App no: 26.0196

Address: Barrowbridge House Club Street Barrow

**Proposal: Approval of details reserved by condition 11 (Estate Roads) on
Technical Details 3/2024/0990**

Client Mr S Gill		
Project Proposed Development at Barrow Bridge House Club Street Barrow Clitheroe BB7 9AY		
Drawing Title Proposed Boundary Treatments Plan and Estate Road Details		
Scale 1:100 @ A1	Date May 2025	Drawn LFR
READ DESIGN LTD		
161 - 10 B

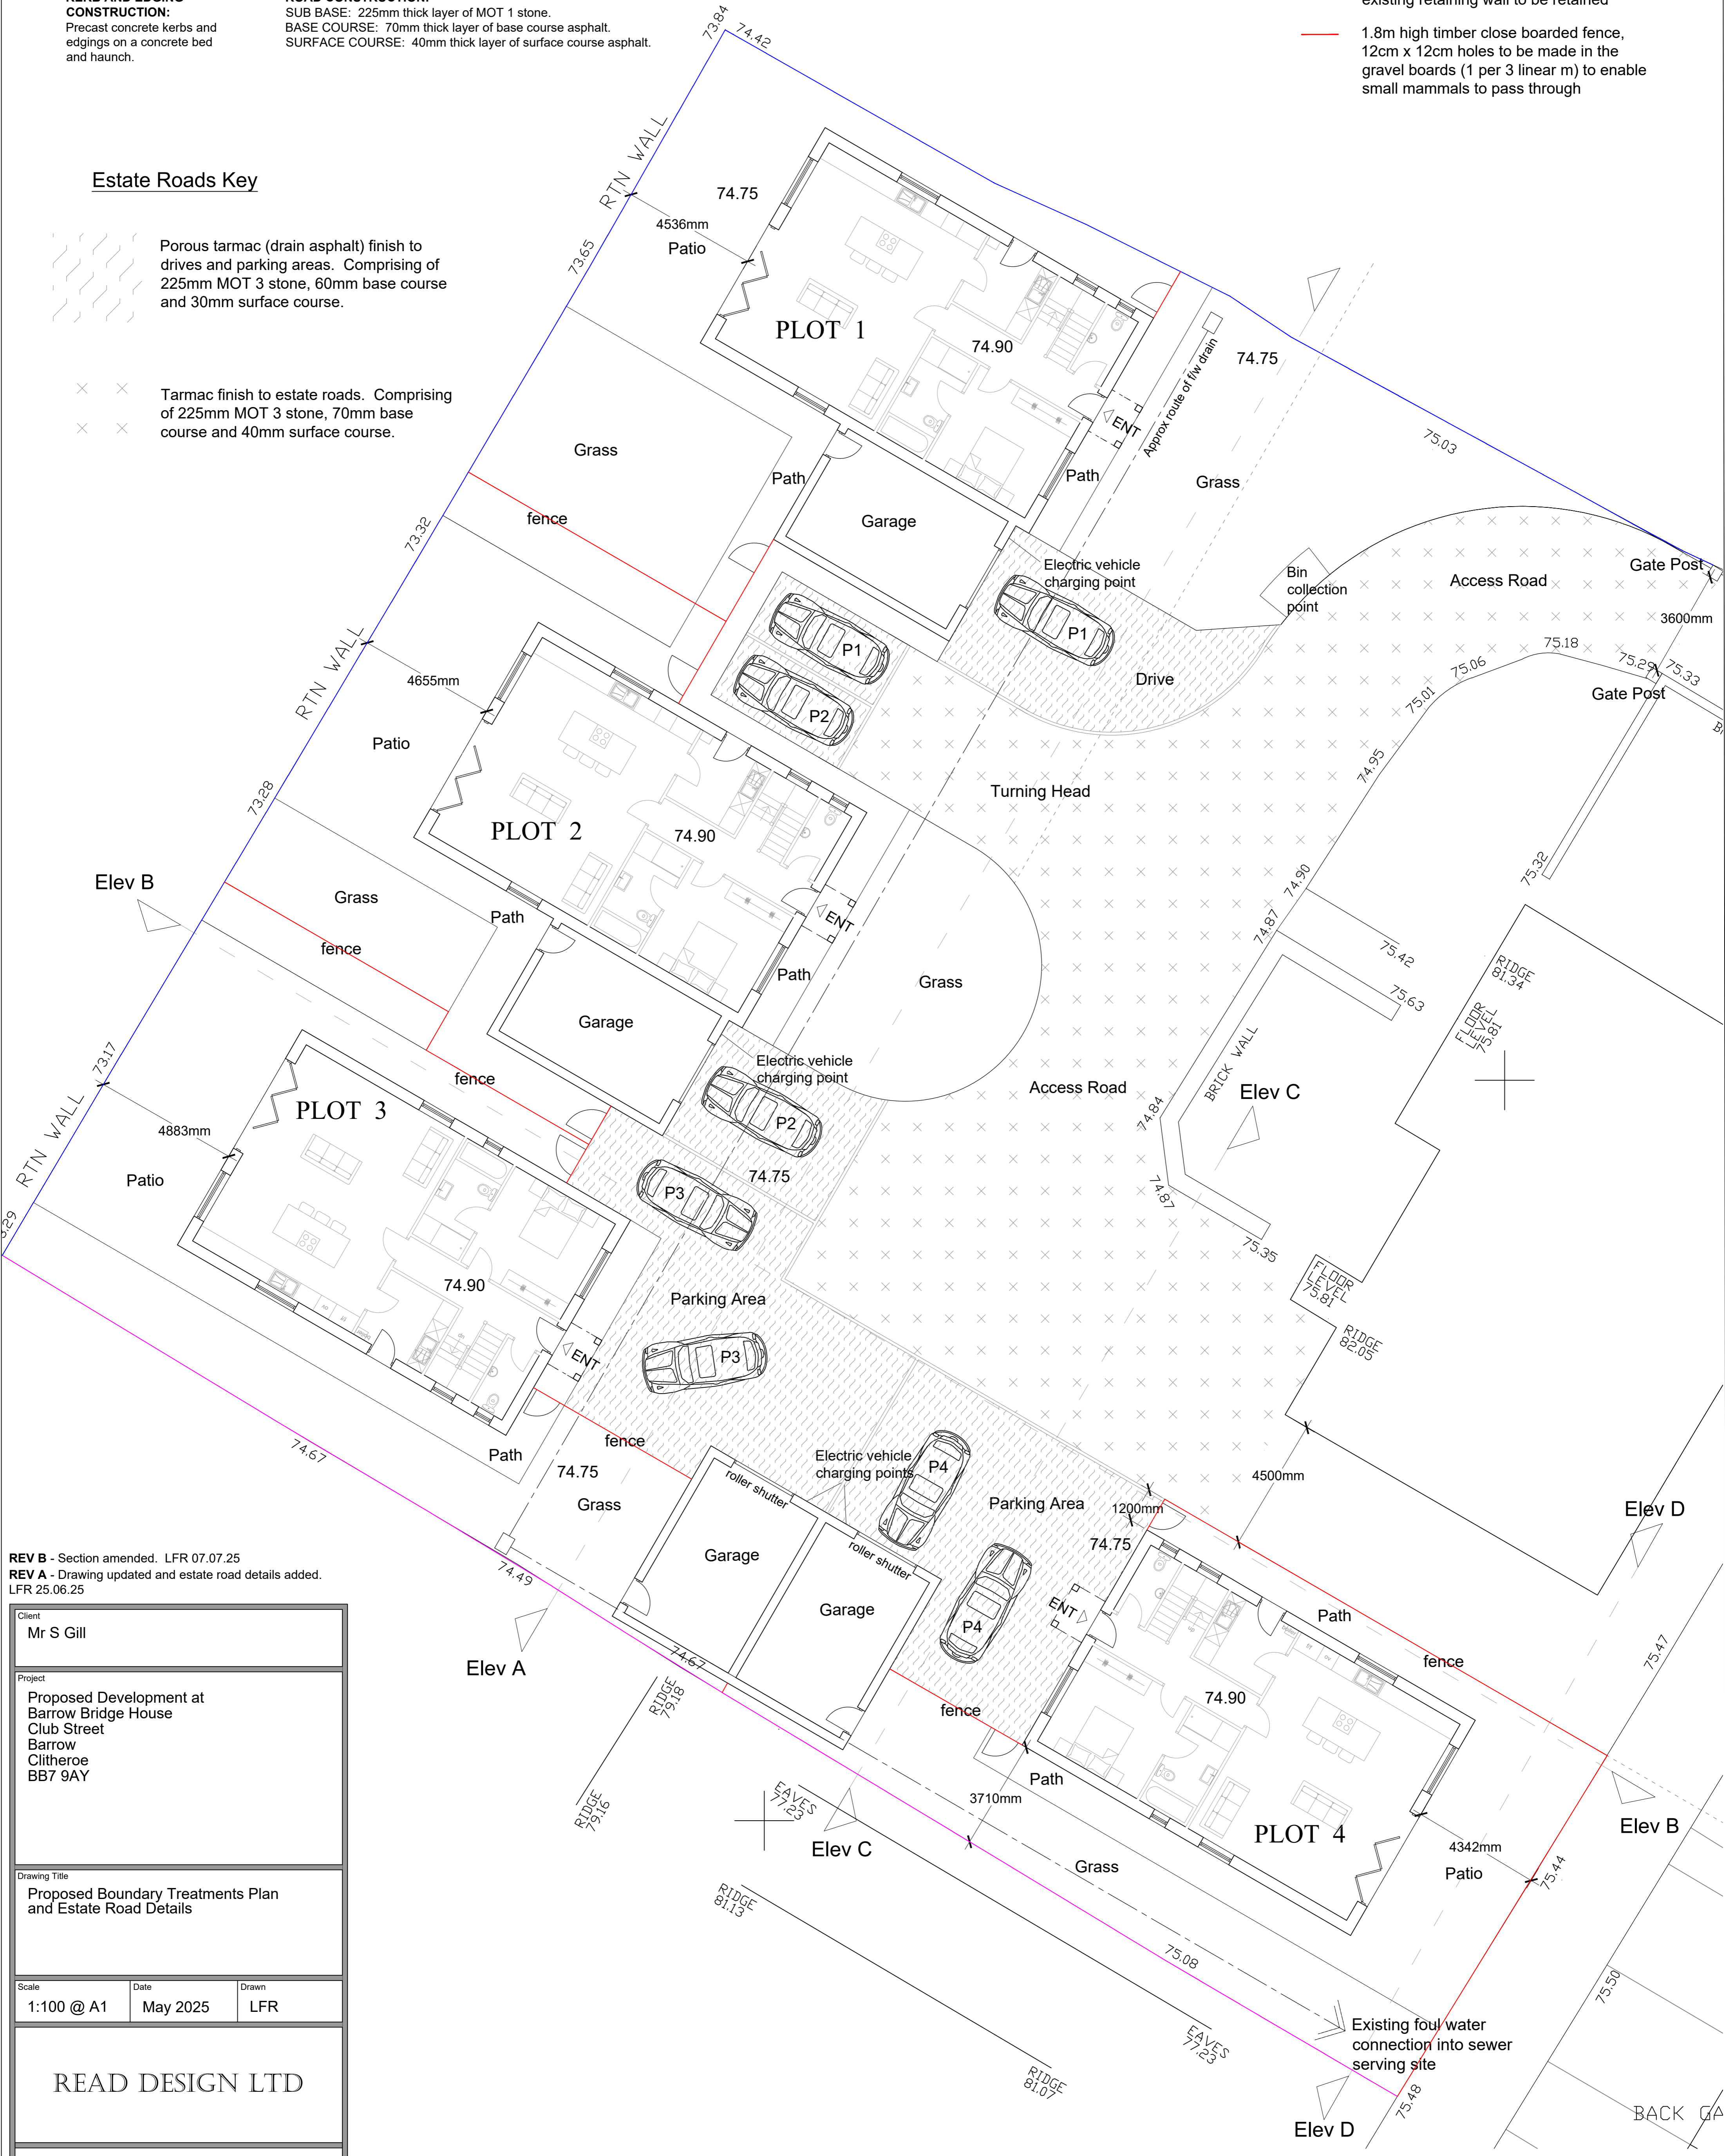
No street lighting will be provided on the estate road and instead a 'floodlight on the entrance gable to each of the 4 plots above the front door on a motion sensor'.

There will be some overspill lighting onto the estate road however it will be dark for pedestrians arriving on foot to the site and vice versa, particularly as plots 1 and 2 are some distance from the estate road.

The estate road is not being formally offered for adoption by Lancashire County Council and is being privately managed and maintained therefore we raise no objection to the discharge of this condition but do highlight the lighting concerns which anticipated to be reflected by the future residents.
